# **Addendum to Review of Ecological Assessments of Warkworth Extension EA and HVO South Modification Projects**

**Prepared by**  
**Umwelt (Australia) Pty Limited**  
**on behalf of the**  
**Department of Planning**

Project Director:	Barbara Crossley		
Project Manager:	Tim Crosdale		
Author/Technical Manager:	Travis Peake		
Report No.	2908/R04	Date:	August 2011

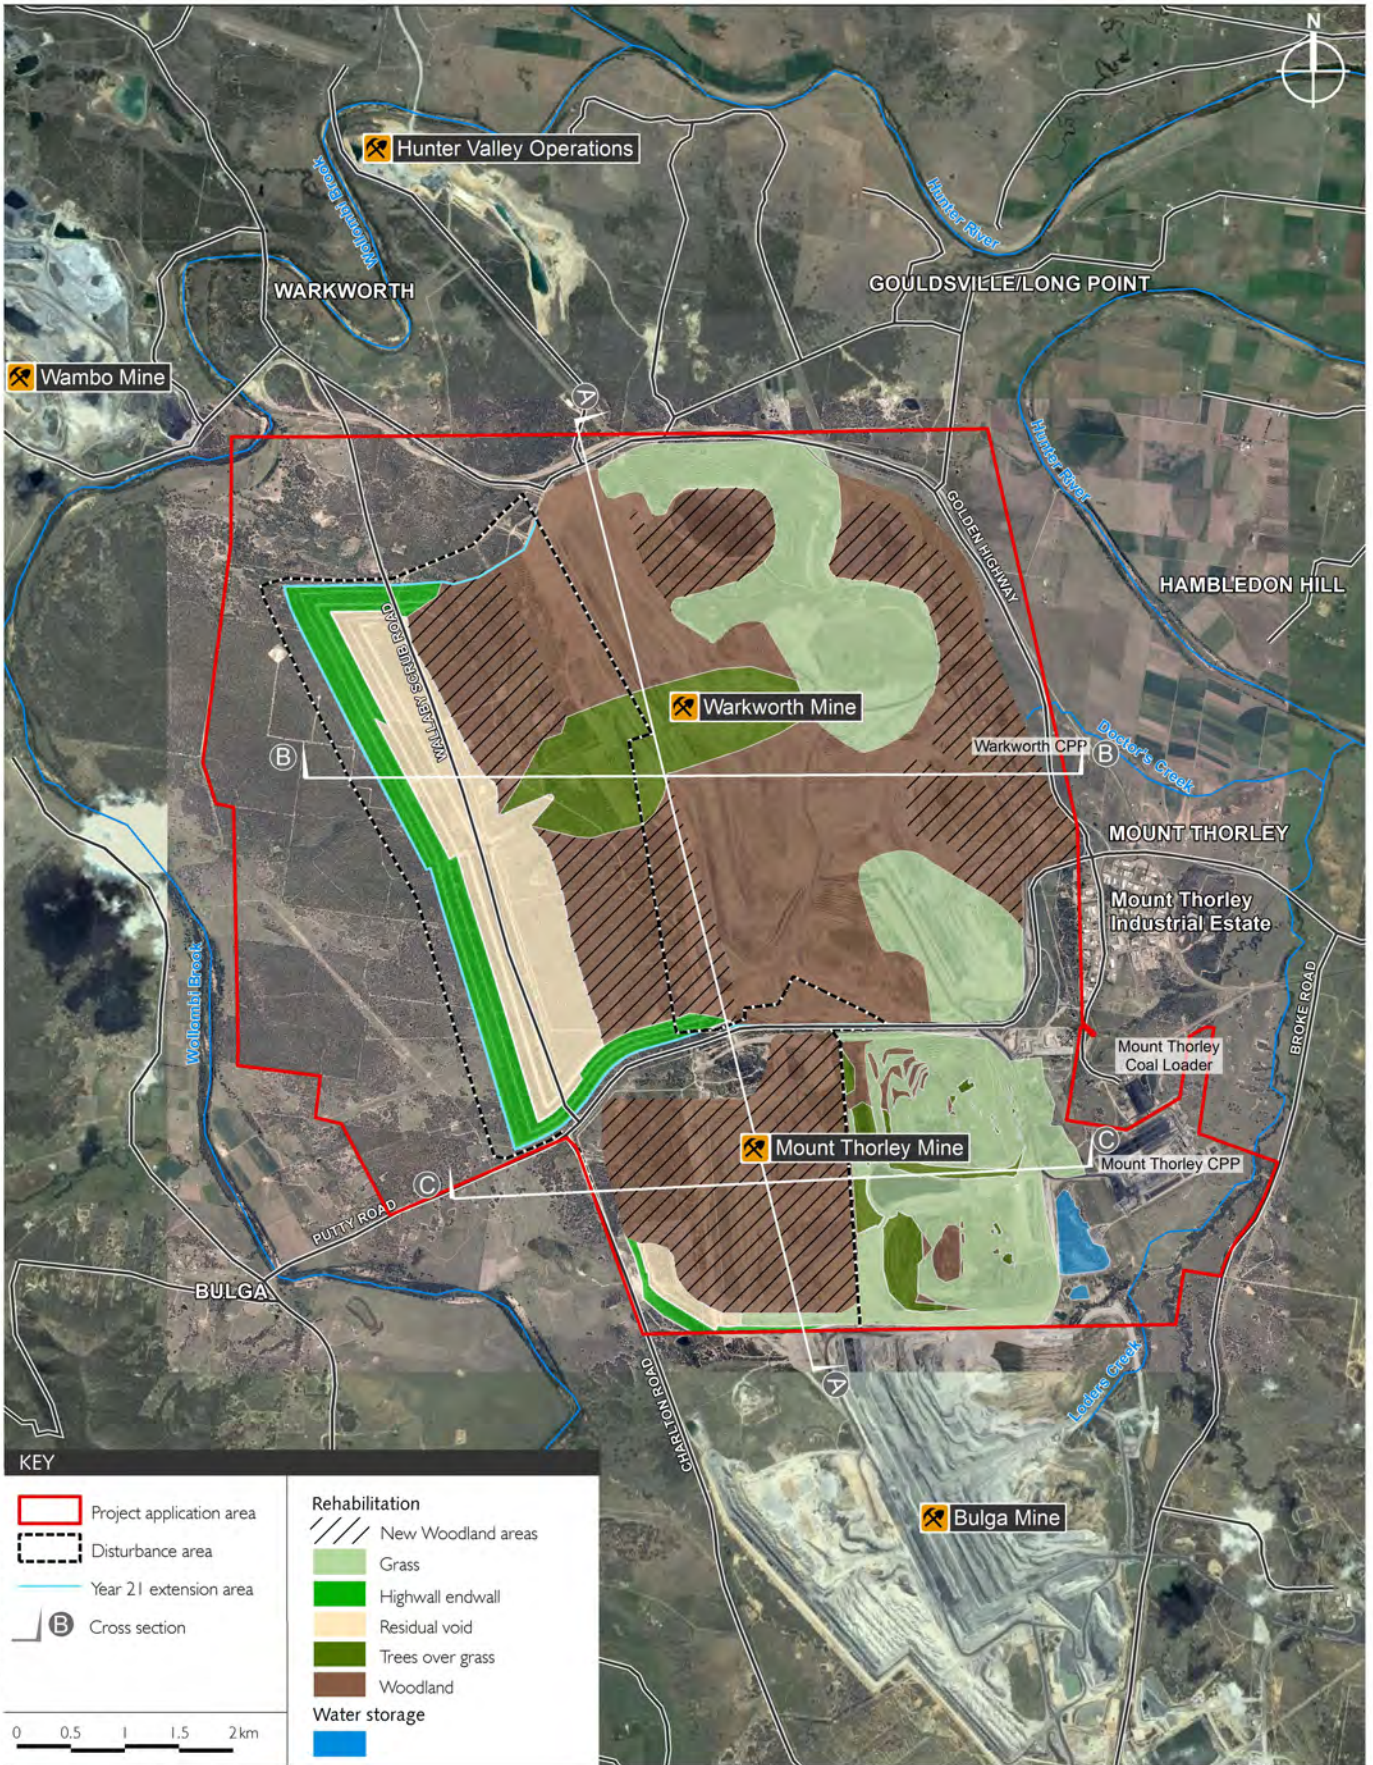
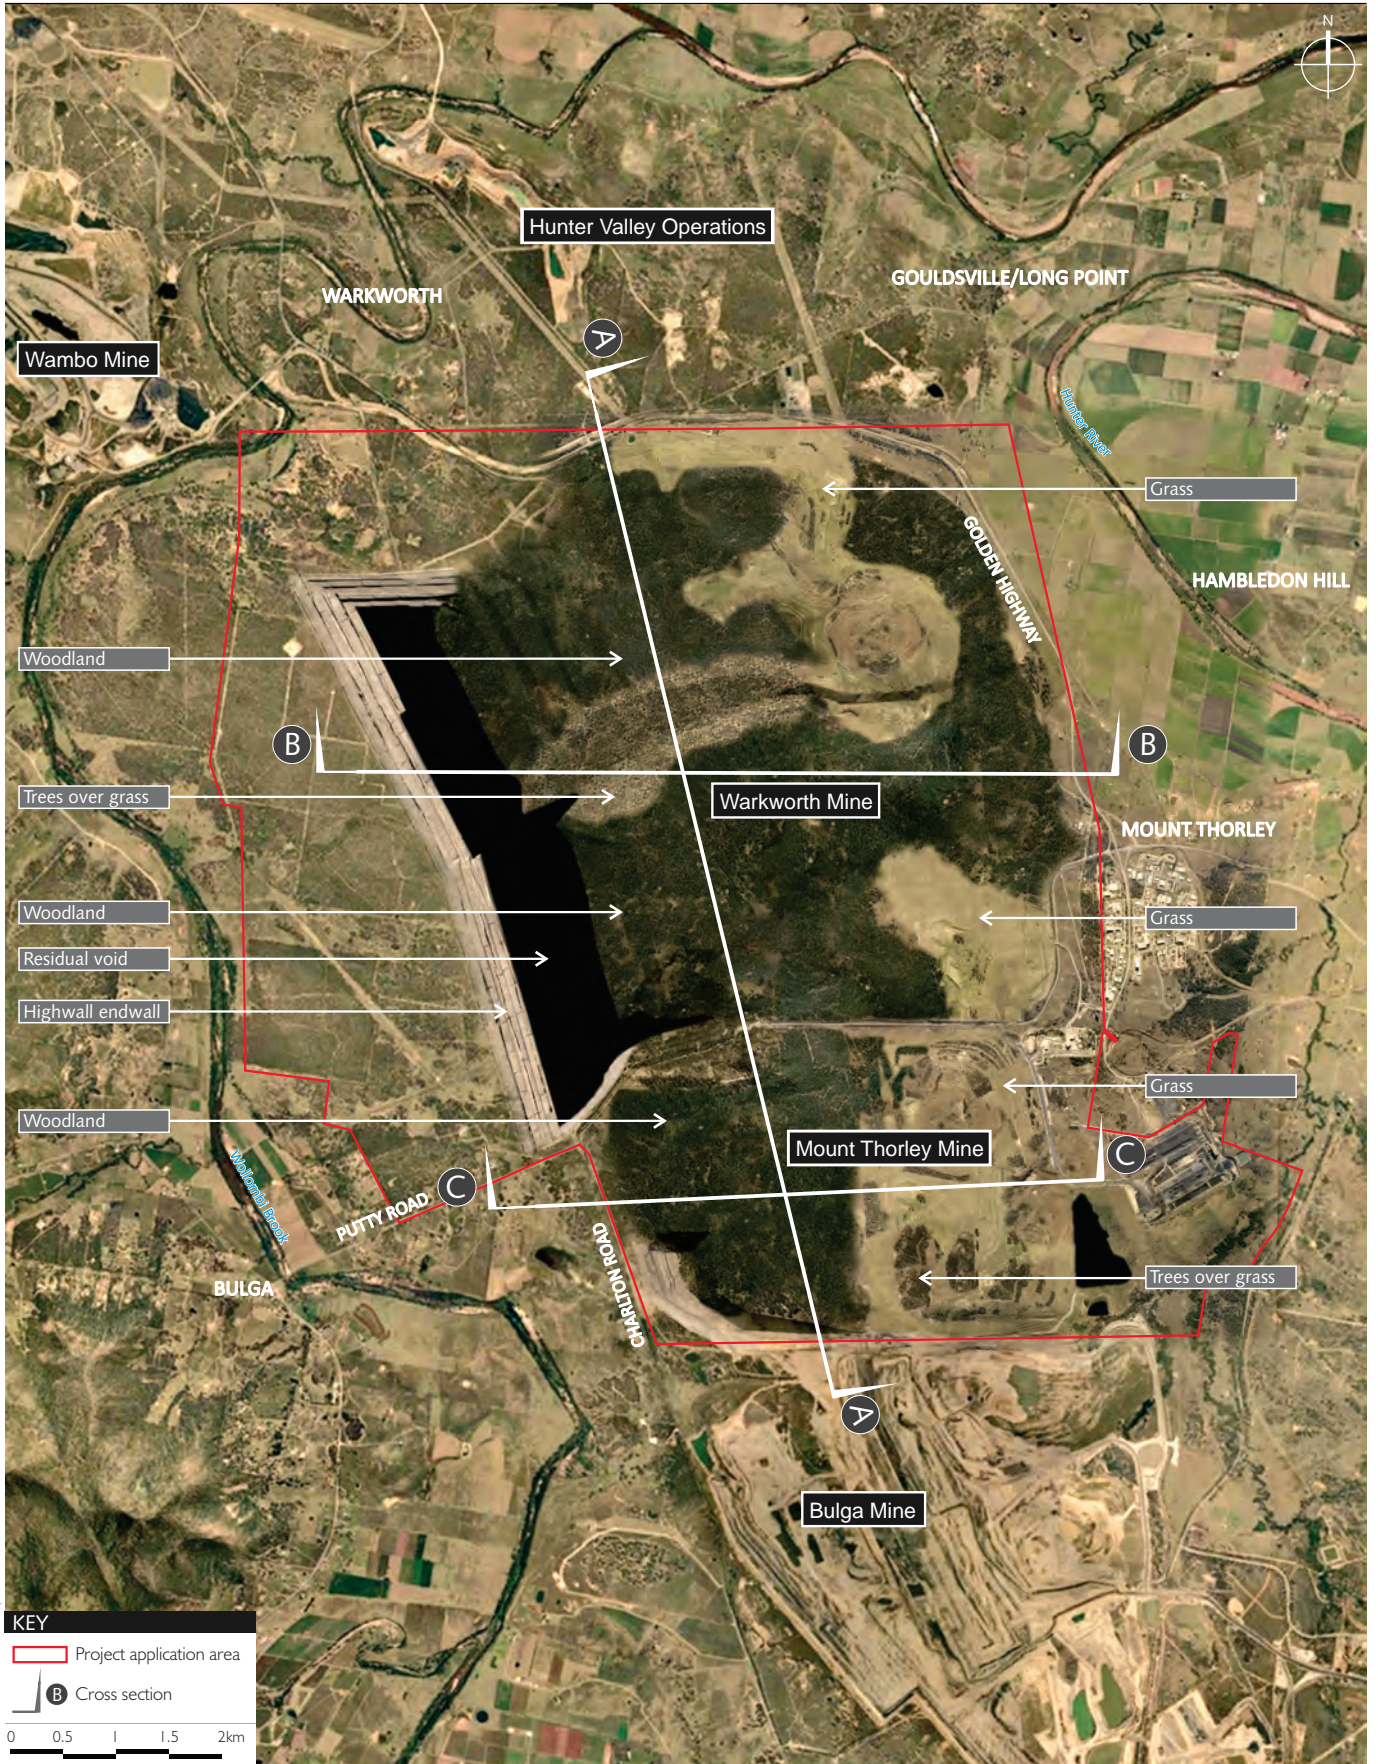
RTCA has undertaken a review of rehabilitation commitments, which, based on the EA, comprise the rehabilitation of 780.6 hectares of CHGBIW EEC (or the CHISGBGF EEC). Russo (2011) indicates that an additional 1336 hectares of mine lands has been identified as suitable for the re-establishment of this community. The letter states that area is illustrated in Figure 1, however the letter does not contain Figure 1. For this assessment the author has assumed that what is listed as Figure 5.5 (opposite p. 6) in the letter is what the text refers to as Figure 1, although this figure does not clearly illustrate where the EEC would be rehabilitated. In this report the area is shown in **Figure 2.2**, and the associated areal extent is included in the tables in **Appendices 1** and **2** to this report. It is assumed that the areas mapped as 'Trees Over Grass' and 'Woodland' correspond to the areas proposed for EEC rehabilitation. It is recommended that RTCA re-issue this map to clarify where the EEC is proposed to be rehabilitated.

Russo (2011) states that this represents an approximate 160 per cent increase in the area previously committed to rehabilitation of this community, and that RTCA is now committed to rehabilitating a total of approximately 2114 hectares on mined lands. The letter is not entirely clear regarding the new commitment. It various states that an additional 1366 hectares is available for CHGBIW rehabilitation, but this and the existing commitment of 780.6 hectares add to 2116.6 hectares, not the stated 2114 hectares. Furthermore the letter says that the additional 1336 hectares 'represents an approximate 160 per cent increase...', however 160 per cent of 780.6 hectares comprises just 1249 hectares.

The letter does not offer a commitment to how the rehabilitation of this community would be undertaken, how it would be measured, or contingency in the case of failure.

4. The revised EEC rehabilitation targets be adopted.
5. RTCA re-issue the rehabilitation map to clarify where the EEC is proposed to be rehabilitated.
6. RTCA clearly documents how the rehabilitation of this community would be undertaken, how it would be measured, or contingency in the case of failure.
7. RTCA document the measures that will be undertaken to improve the timeliness in which rehabilitation is likely to be colonised by threatened fauna species through the augmentation of habitat with appropriate artificial features, such as nest boxes, logs and other groundcover and microhabitats.
